**PROJECT MEMO:** Veranda Subdivision

**RE:** Conditions of Approval

Drawing file: Revised Site Plan 04.02.2013 / C-300 032913.pdf

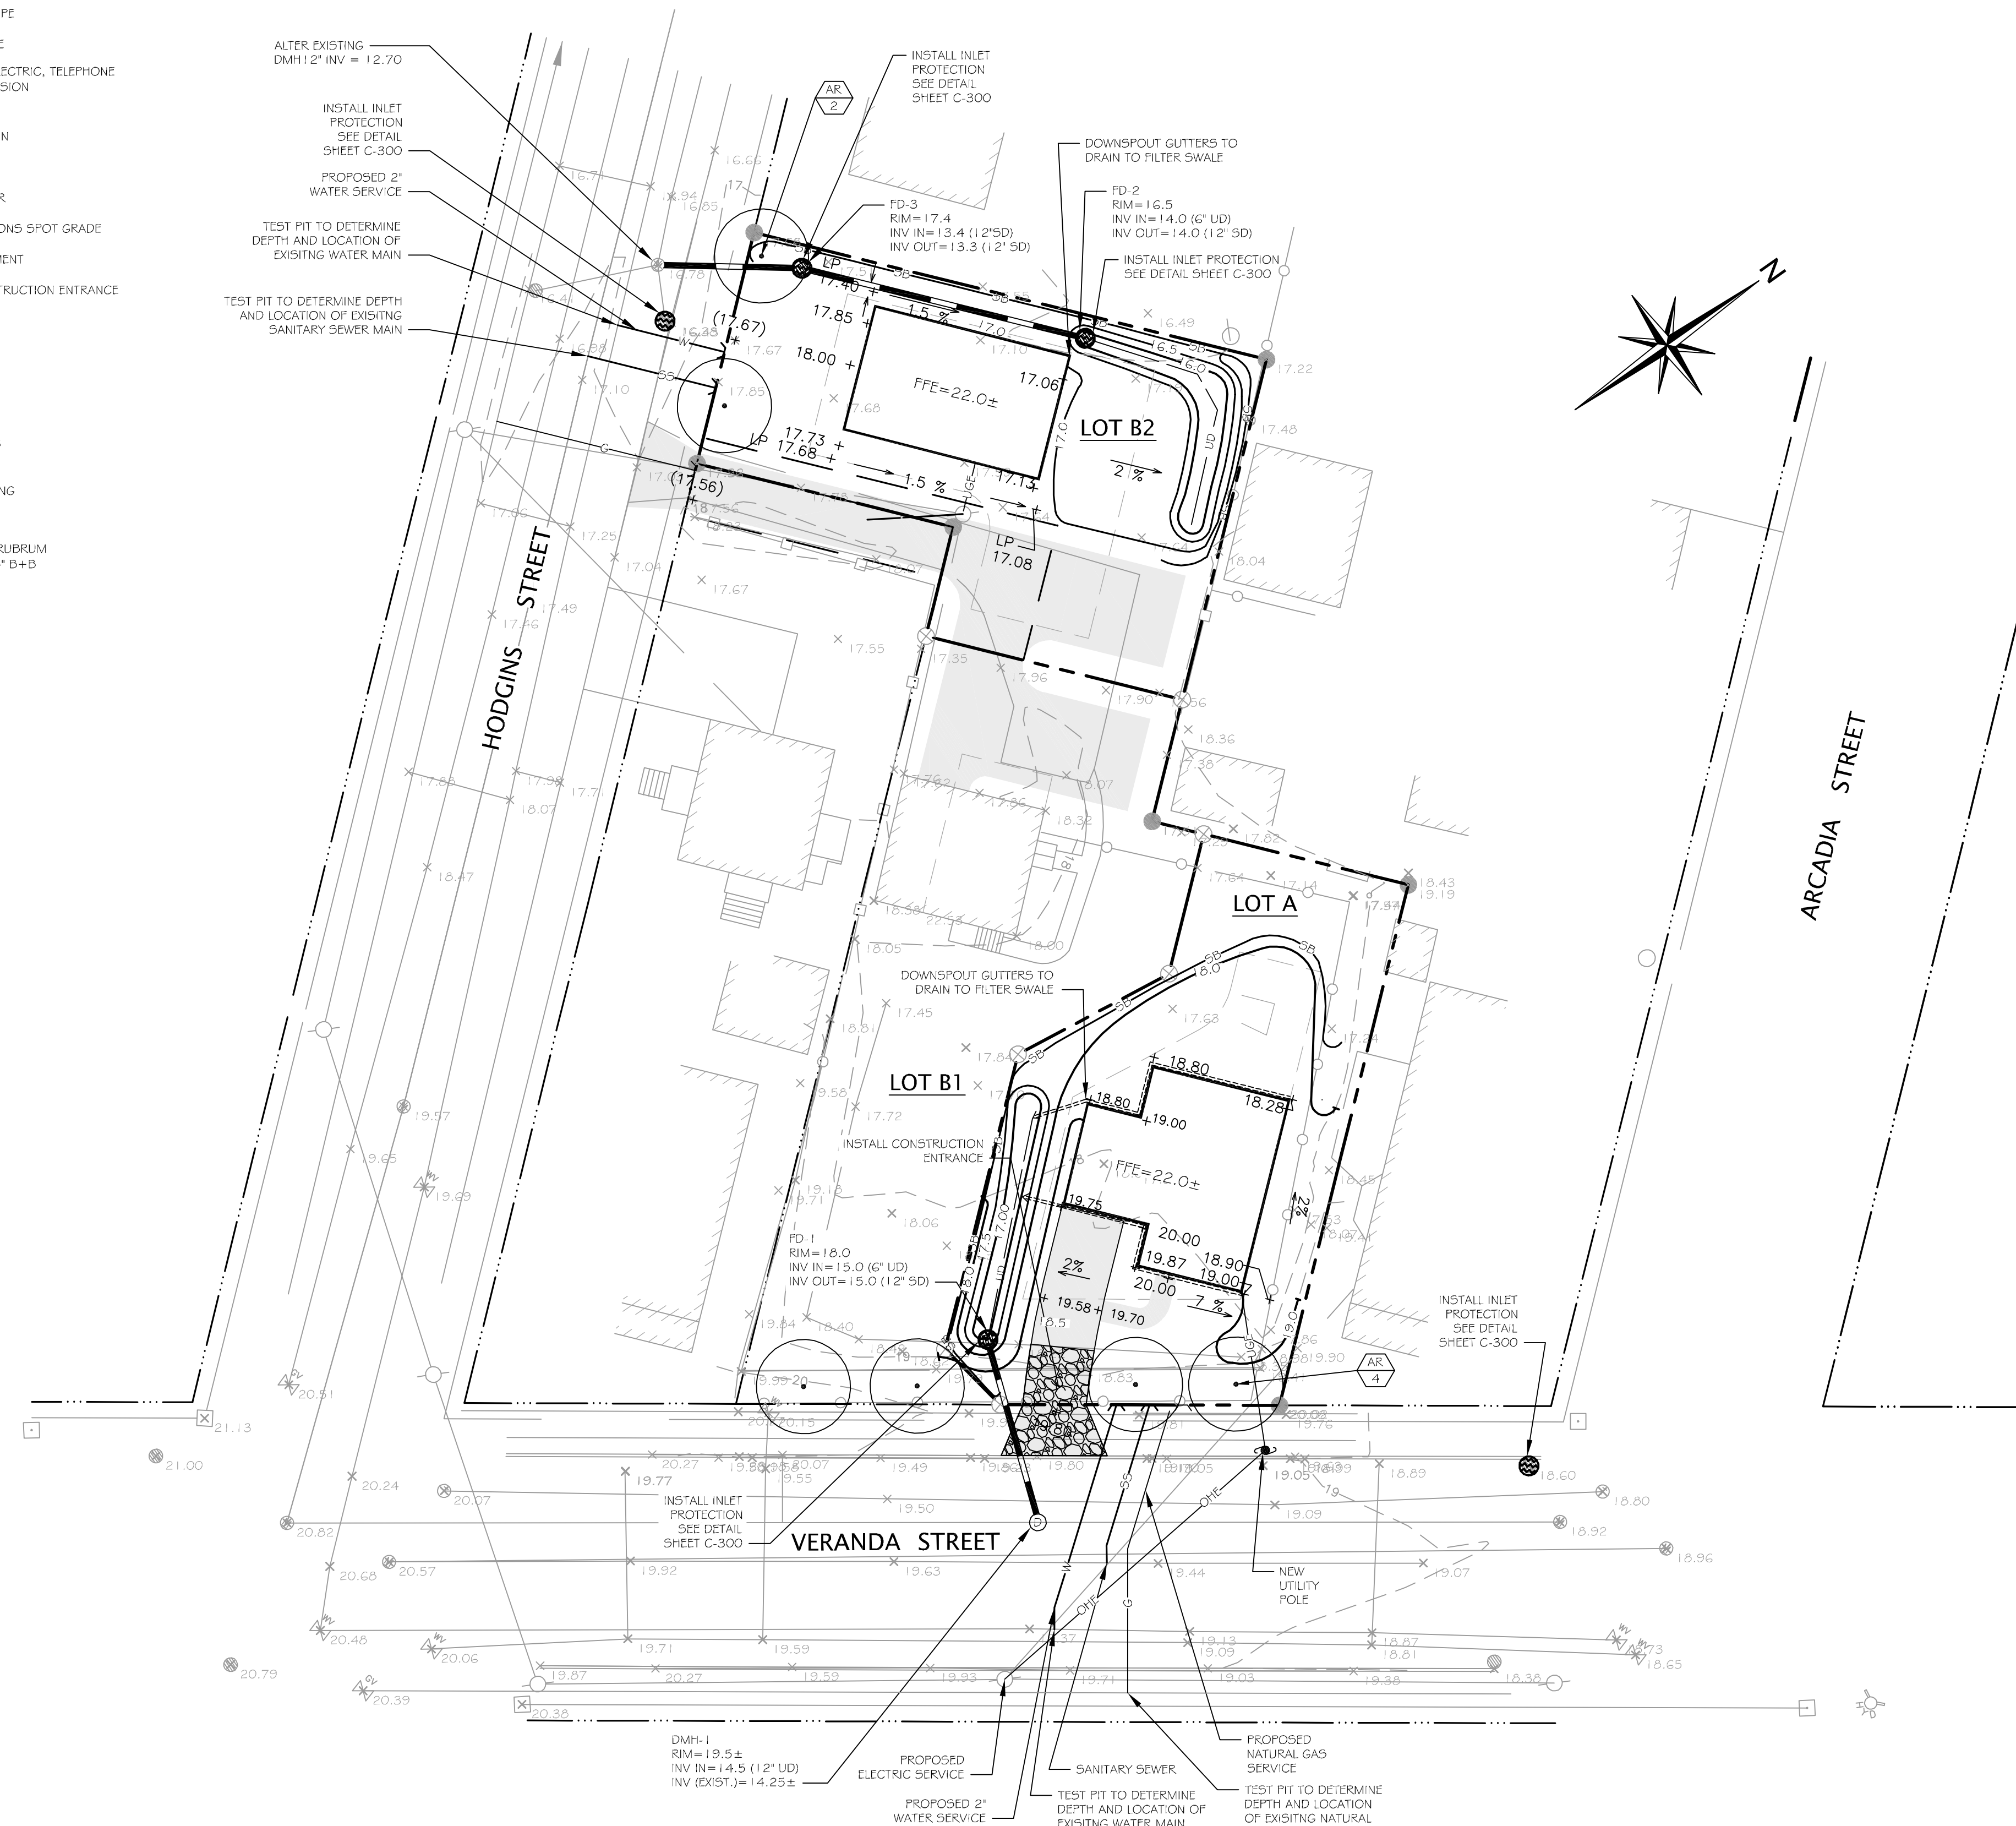
**Per your review only Comment #2 remained unresolved.** *Comment #2: Please add note to plans that all work within the road right of way shall meet Portland Technical Manual standards.*

**Response:** The note is on Construction Note 1, Sheet C-100.
